DECISION DELEGATED TO HEAD OF PLANNING

Application No: H14-0224-26 **Applicant:** Mr & Mrs B Hutson
Proposal: Proposed first floor side extension and alterations
Location: 14 Forge Crescent Pinchbeck Spalding
Terminal Date: 11th May 2026

CASE OFFICER ASSESSMENT

FRONT ELEVATION

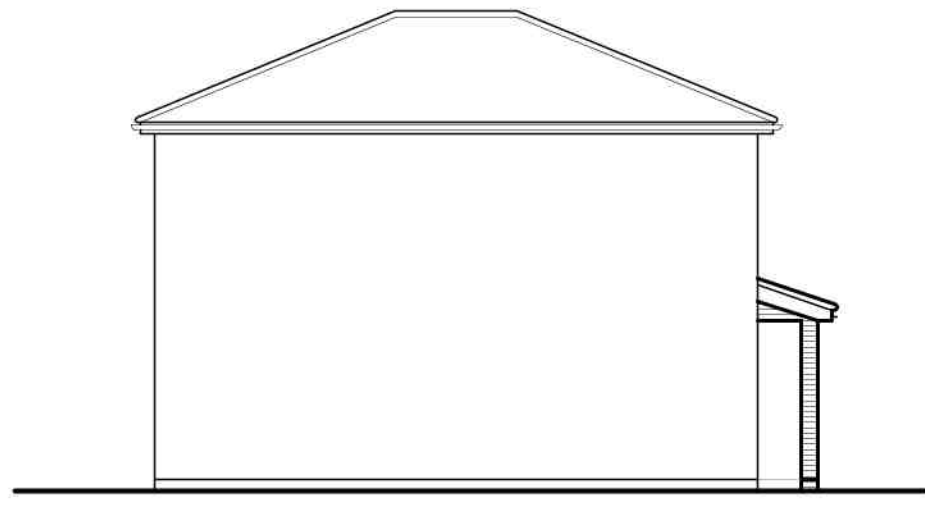
This is a householder application for a first floor side extension, and additional alterations at 14 Forge Crescent, Pinchbeck. The extension would measure 3m (width) by 7.86m (depth), being placed above the ground floor garage. The eaves would be level with the host at 4.8m, a gable ended roof would be set level with the ridge of the host. All materials would match the host.

It is proposed that the existing flat roof overhang to the front of the dwelling would be replaced with a mono-pitched roof.

Whilst there are limited examples of first floor-side extensions instead of flat roof garages along the southern side of Forge Crescent, there are examples already in situ. The existing examples of comparable developments would help to naturalise the proposal to a certain extent. The use of a gable ended roof, which is indicative of counterparts in the area, further helps to naturalise the proposal in this regard. The use of materials to match the host would further aid the integration of the extension.

The proposed hip to gable roof is somewhat awkward. The difference in slope creates an unusual relationship and prevents the extension from wholly integrating itself into the host. That being said, this would only be visible from limited angles to the west of the site, away from the public realm. On balance, it is not considered that this feature would be so impactful or detrimental as to be considered harmful to the area.

FIRST FLOOR PLAN

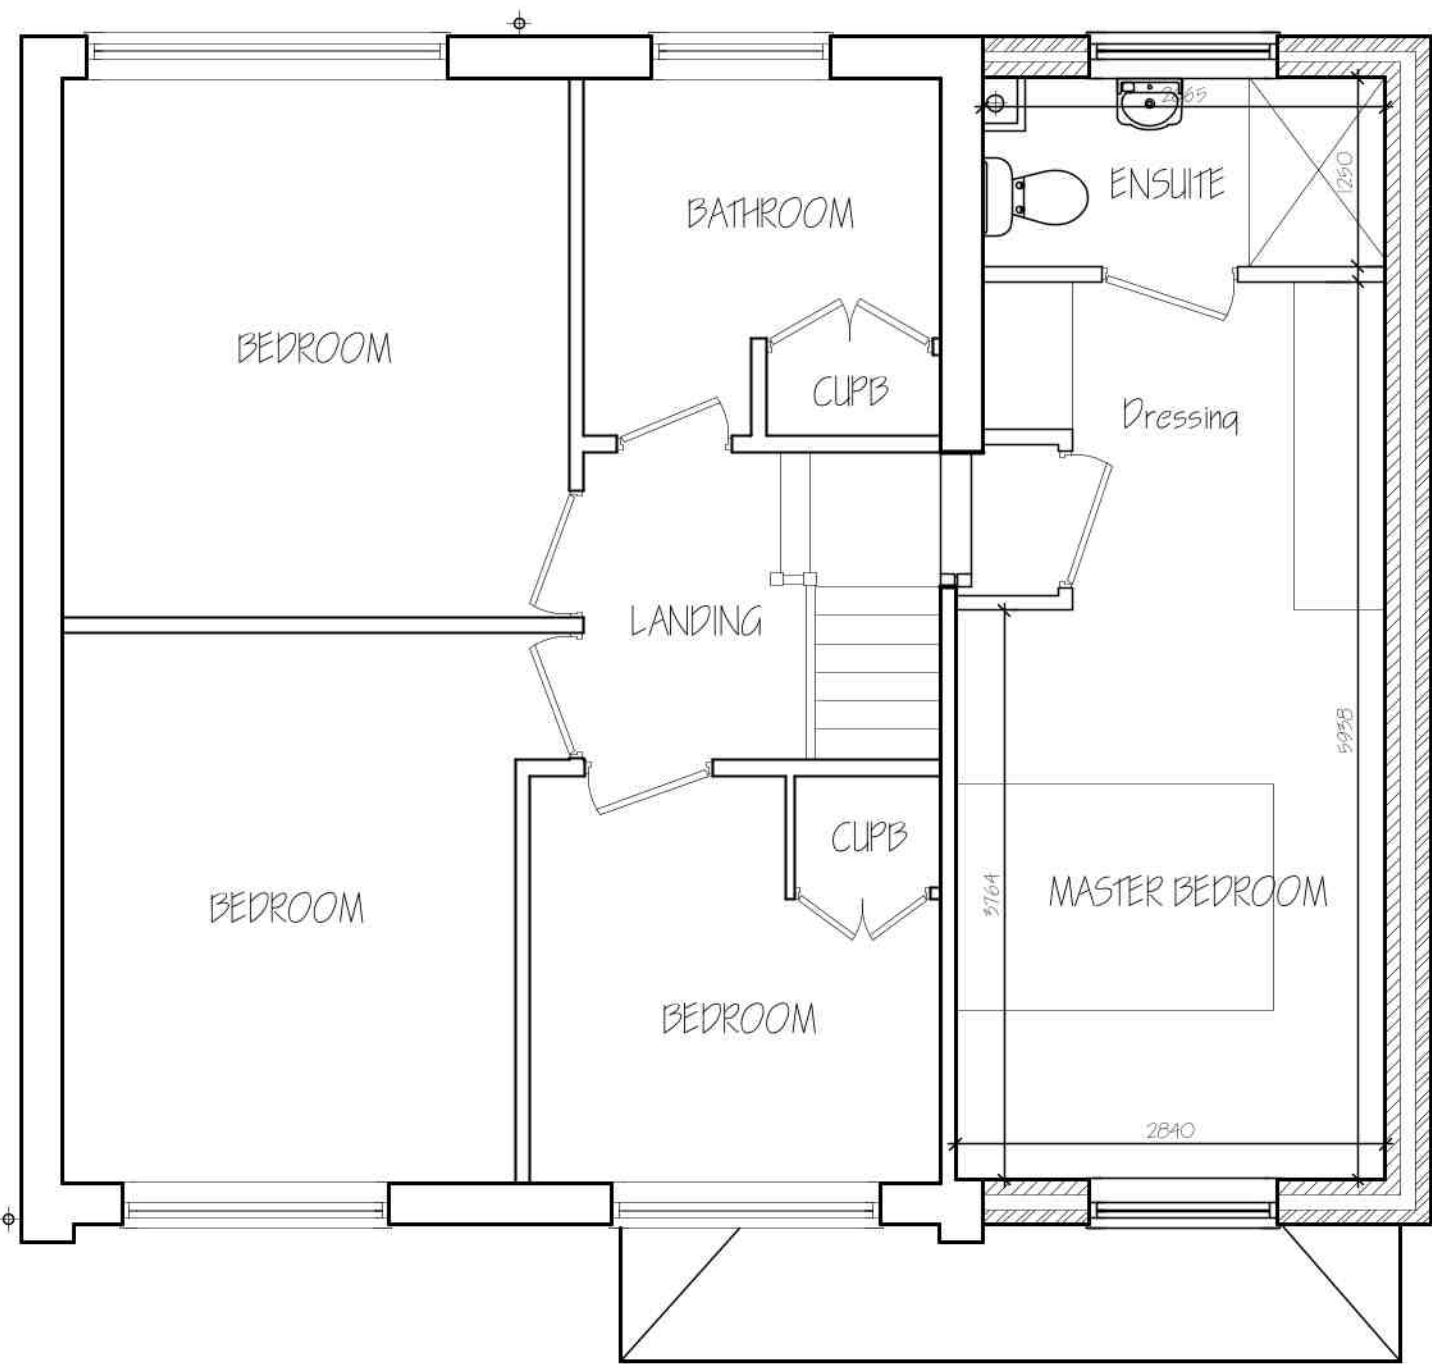
The proposal would increase the level of shadow cast. However, this shadow would fall onto blank elevations preventing harm. The proposed windows would not overlook neighbours.
